POST TRI-PARTY ALTERATION REPORT

THE FARM
BESSBOROUGH
BLACKROCK
CORK

MARCH 2022

ROOF PLAN-BUILDING C

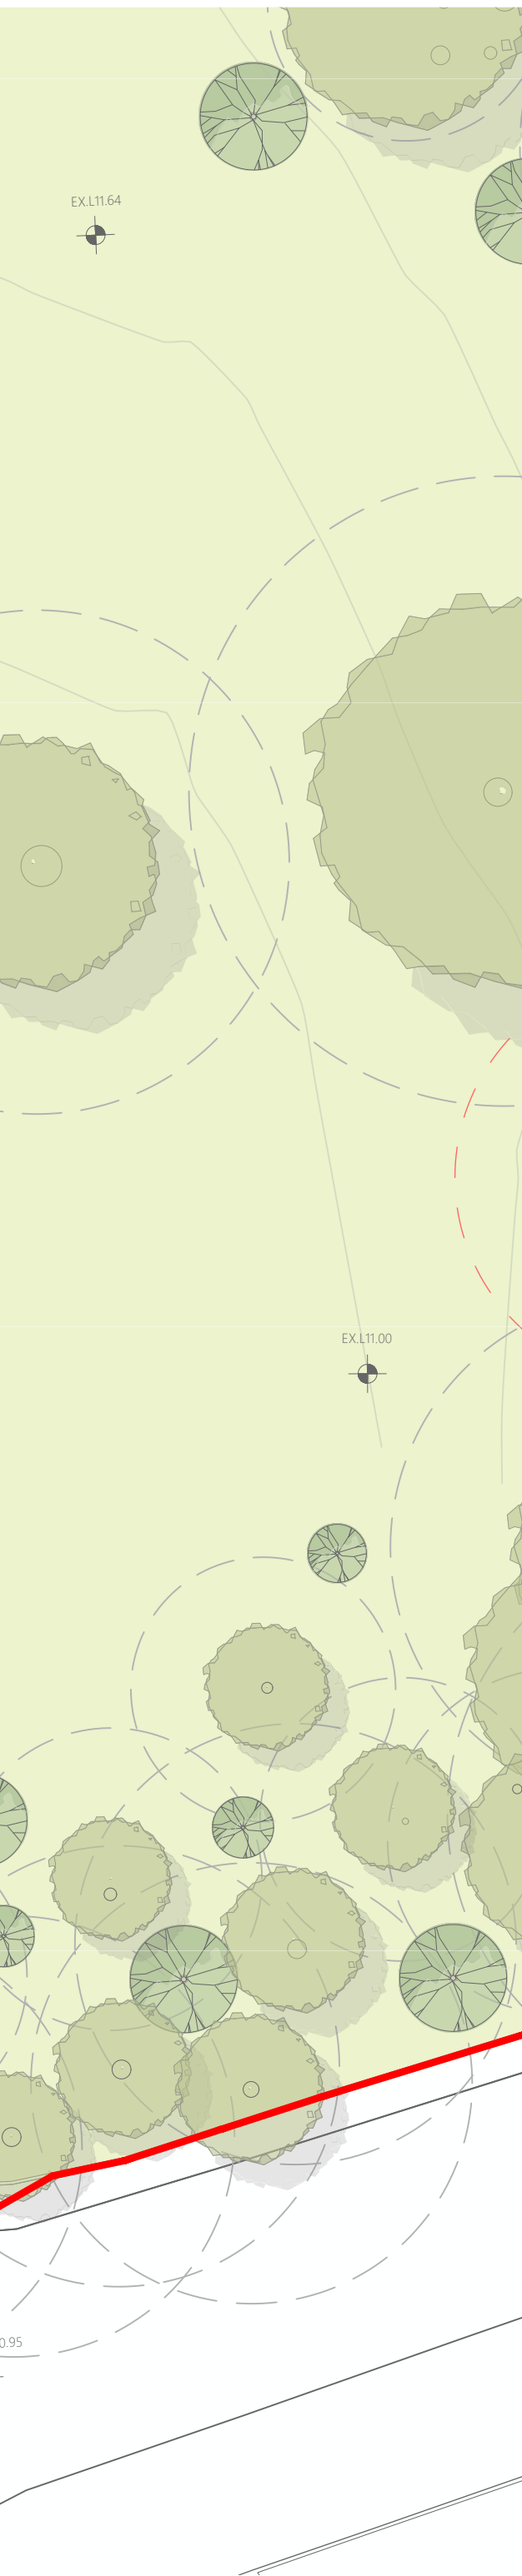
Scale and expression of building C next to car park has been softened and adjusted to hug boundary

Drawing file: Site Drawings / SB-2020-107 401 PEDESTRIAN ACCESS GATE COMPLIANCE.pdf

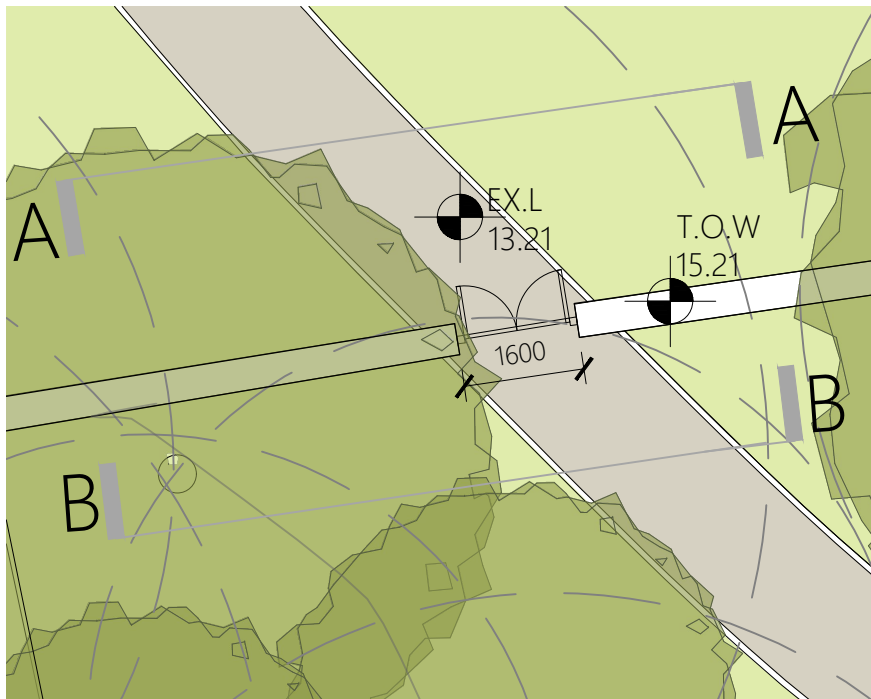
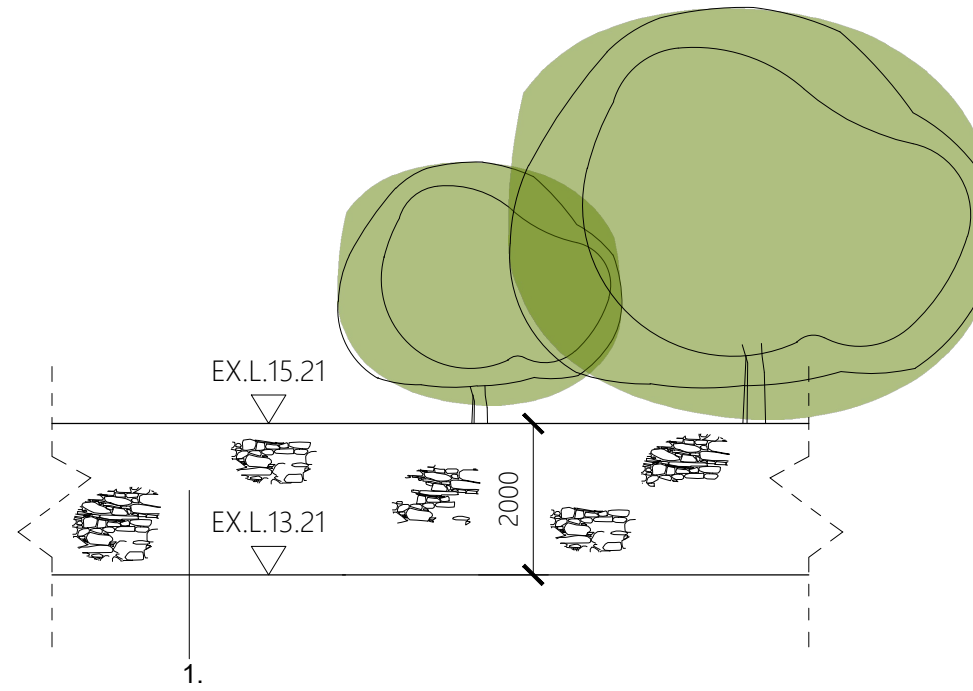
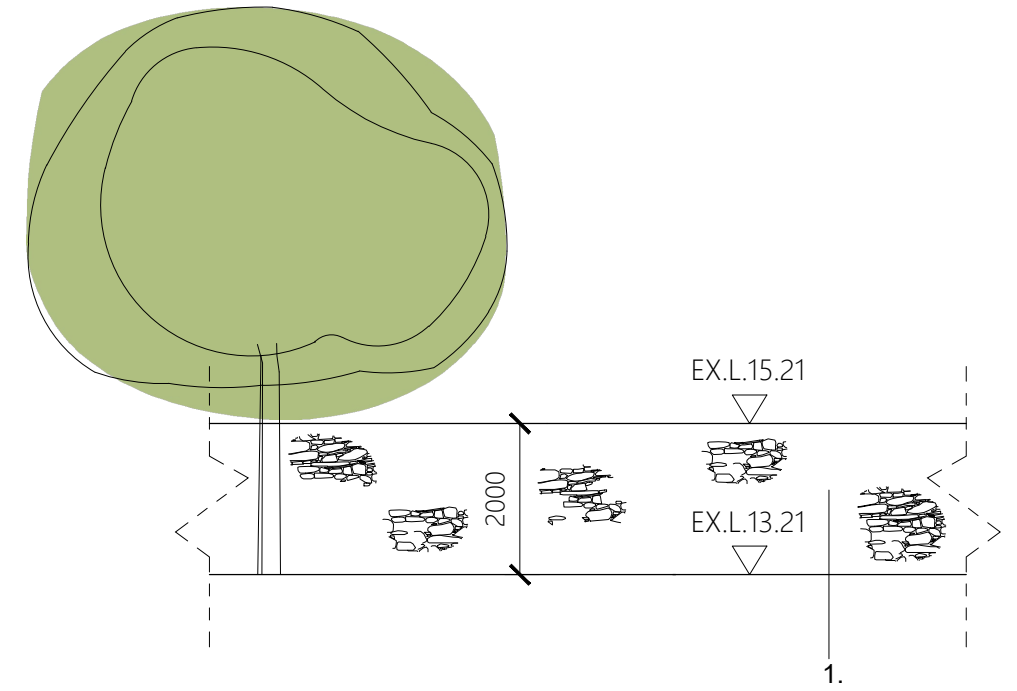
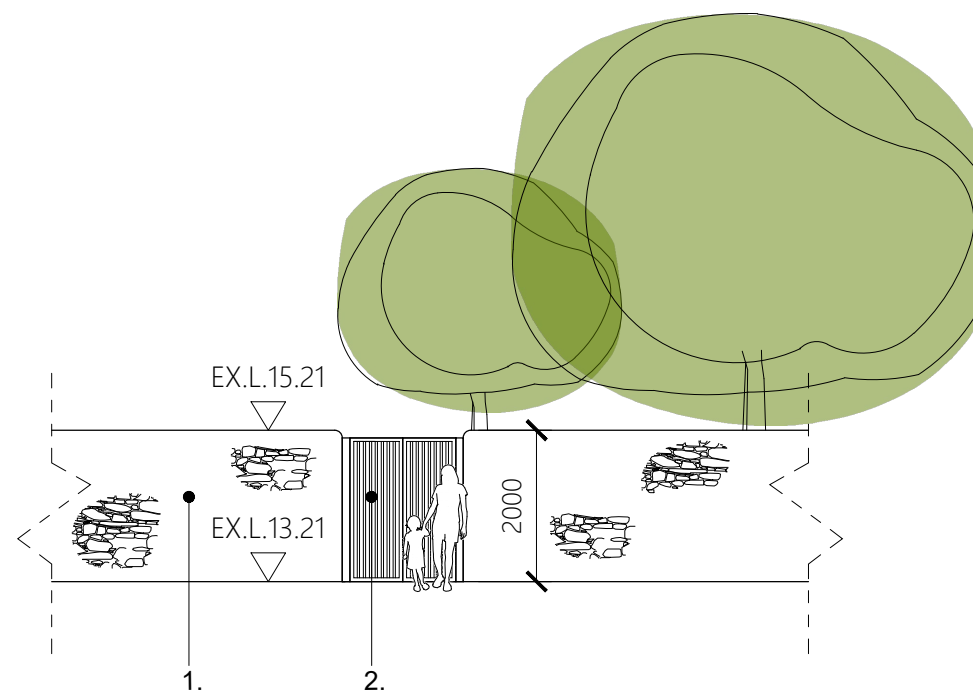
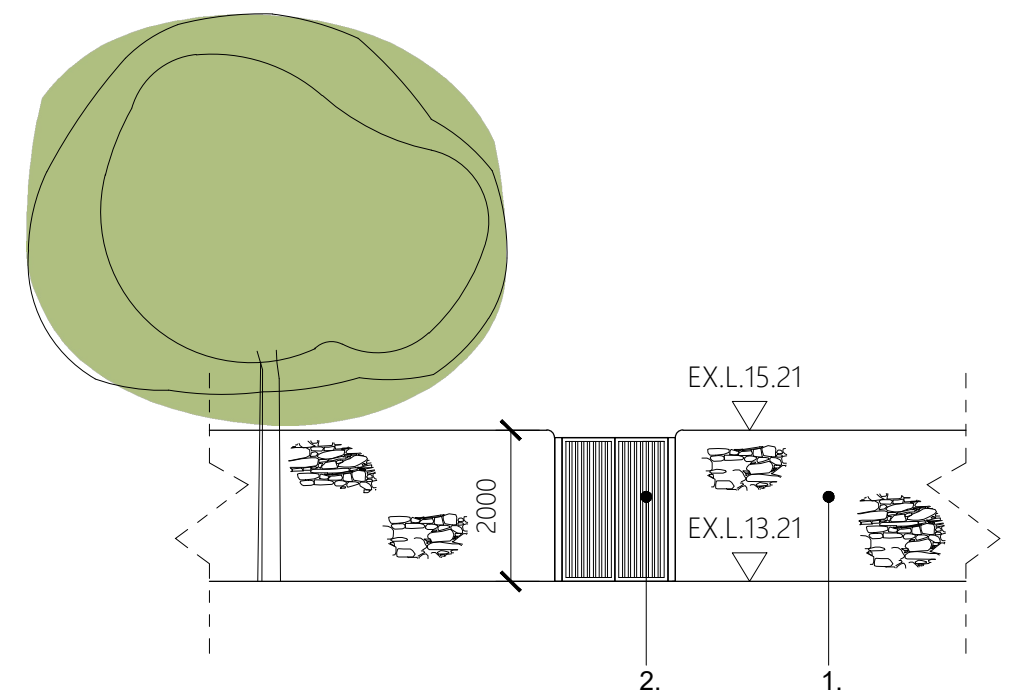
Pedestrian route altered to allow easier access to the site, with new gate to site adjacent from existing pedestrian crossing to the north of the site.
